Memorandum

To	Argot Ansons Design Manager CDSJV	From	Harry Asche
Copy	Troy Burton, David Oliveira, Mark Percival, Sam Norton, Diane Mather	Reference	M5N-AJV-MEM-150-500-TR-02017_A
Date	14 March 2017	Pages (including this page)	9
Subject	Proposed Changes to Infrastructure approval for SSI 6788; with respect to settlement criteria

Figure 19-8 Predicted drawdown caused by the project

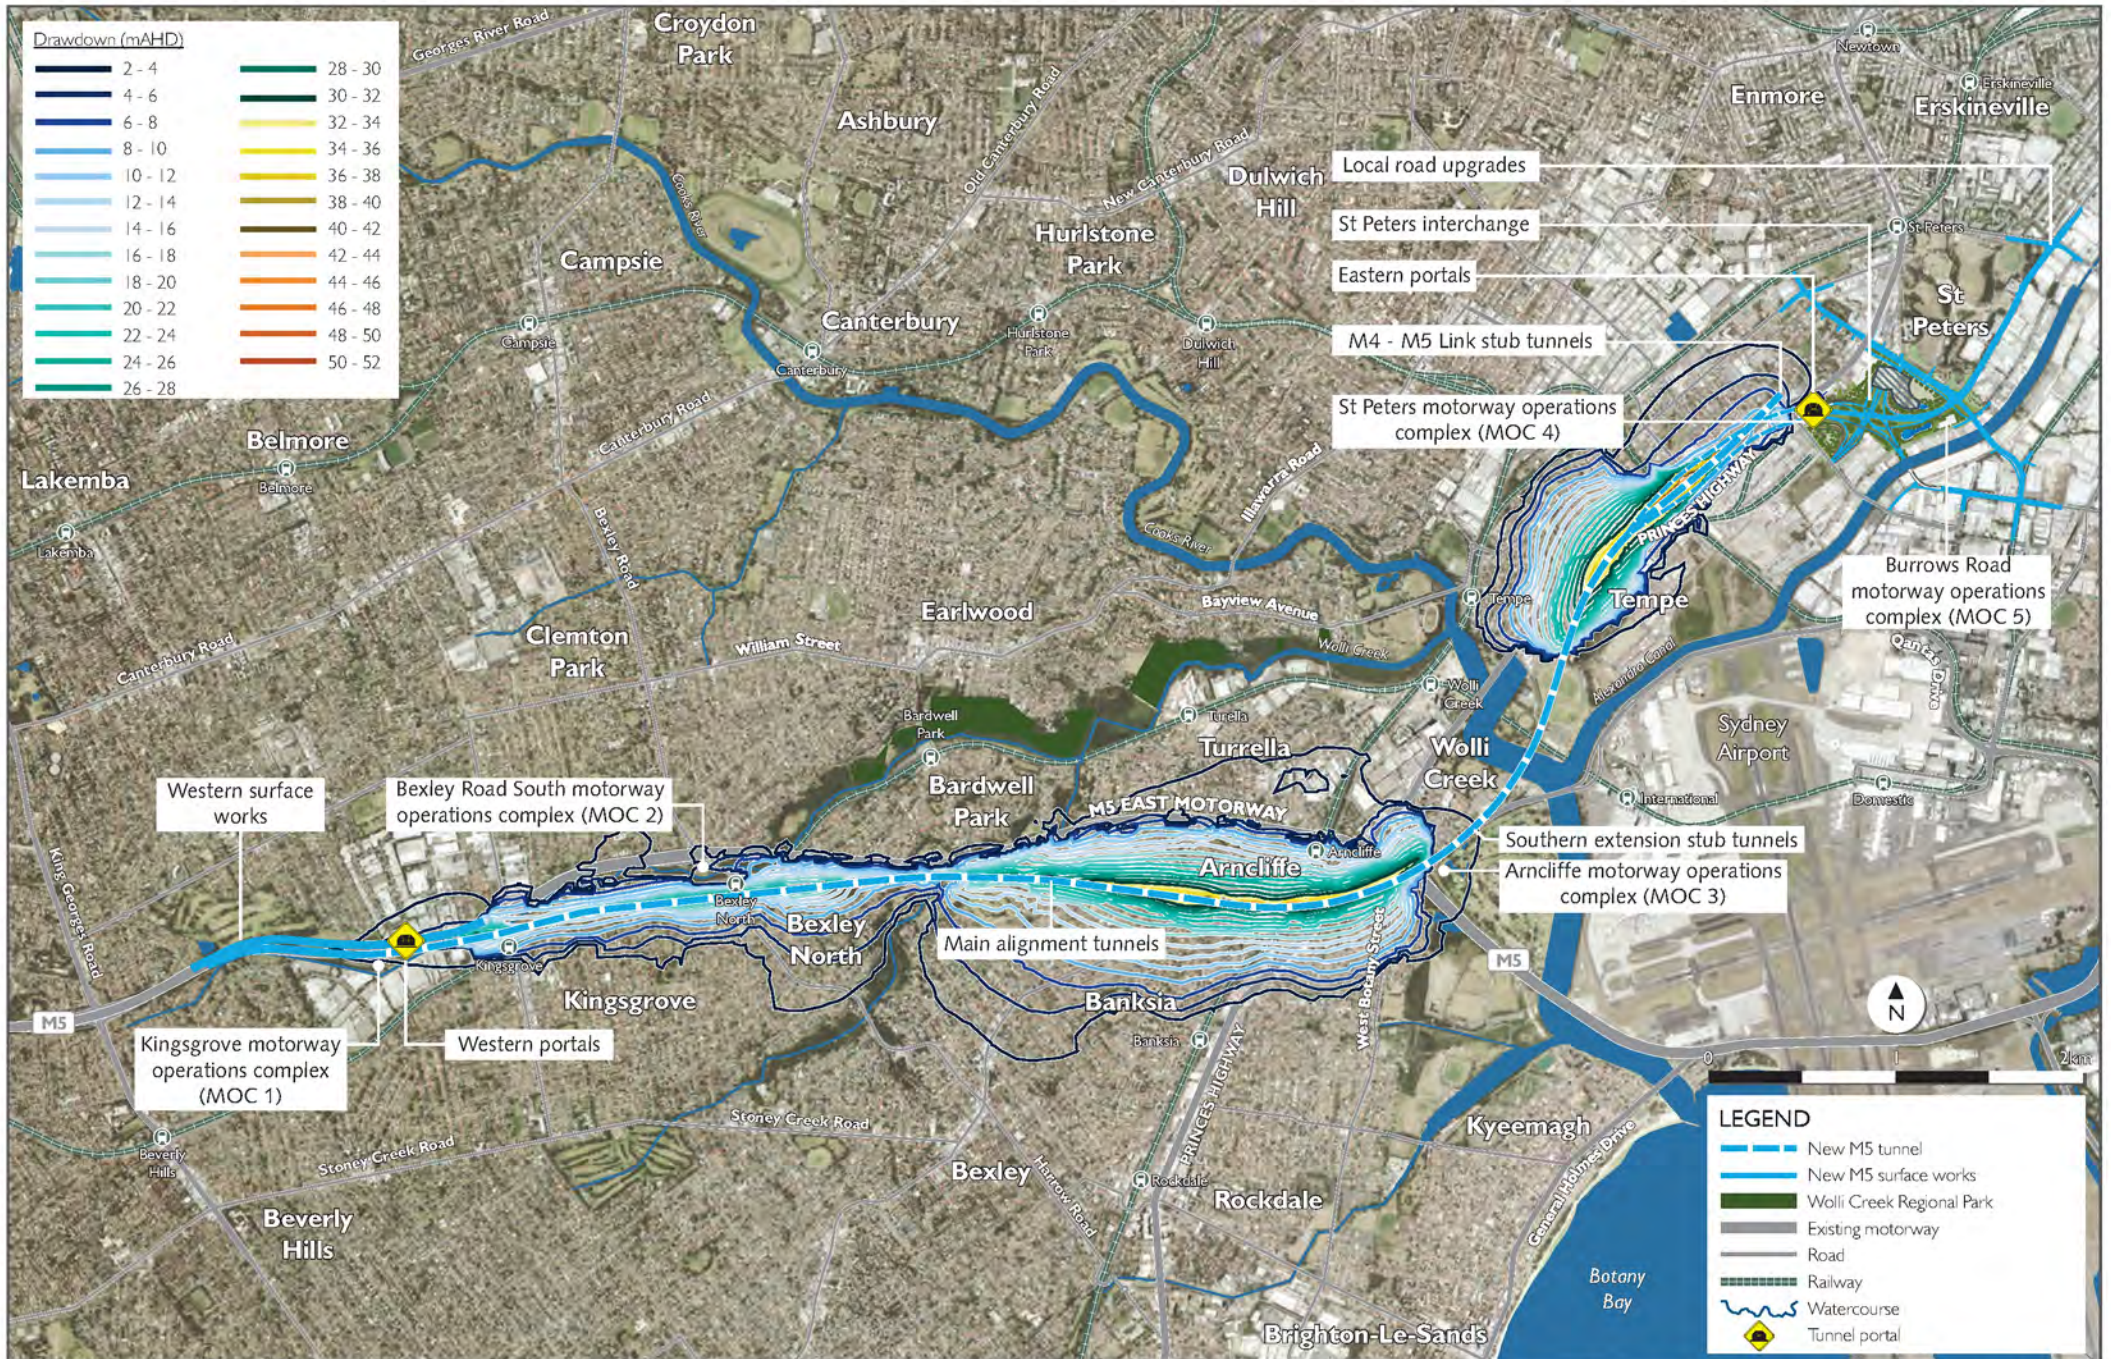
Settlement and surface impacts are discussed in EIS Volume 1B, Chapter 13. Chapter 13 describes the two causes of settlement being “volume loss during tunnel excavation”, and “groundwater drawdown and subsequent ground consolidation.” The same section describes the cause of damage to buildings: “Settlement of the surface can create tensile strains in buildings above and around the settlement.”

Details of settlement predictions and detailed commentary are provided in the EIS Volume 1C, Chapter 19. Figures 19-9 to 19-13 provide the predicted vertical settlement contours due to tunnel excavation (volume loss) along the project alignment. Settlement due to groundwater drawdown is discussed on pages 19-62 and 19-63. The discussion includes the following statements:

“The predicted magnitude of the groundwater drawdown settlement can be quite high, but the settlement is usually spread over a wide area and is unlikely to cause significant horizontal strain or bending strain in buildings. The settlement that occurs due to groundwater drawdown generally occurs very slowly, possibly over years, and is often indistinguishable from settlement that is already occurring due to groundwater drawdown that might already be occurring and seasonal effects related to swell and shrinkage of the soil.”

From the Infrastructure approval for SSI 6788, Part D8 contains Table 1, which contains reference to an absolute value of settlement. Applying this Table 1 to the predictions of groundwater drawdown settlement is not in accordance with the descriptive words in the EIS, nor does this effectively protect the building infrastructure against the actual effects that cause building damage.

In order to establish realistic criteria for impacts of settlement, the project seeks to modify Table 1, by addressing the very cause of building damage – induced tensile strain. The proposed amended Table 1 is shown below:

Beneath Structure/Facility	Limiting Tensile Strain ¹	Maximum Angular Distortion
Buildings - low or non-sensitive properties (i.e. < 2 levels and car parks)	0.1	1 in 350
Buildings - High or sensitive properties (i.e. > 3 levels and heritage)	0.1	1 in 500
Roads and Parking areas	N/A	1 in 250
Parks	N/A	1 in 250
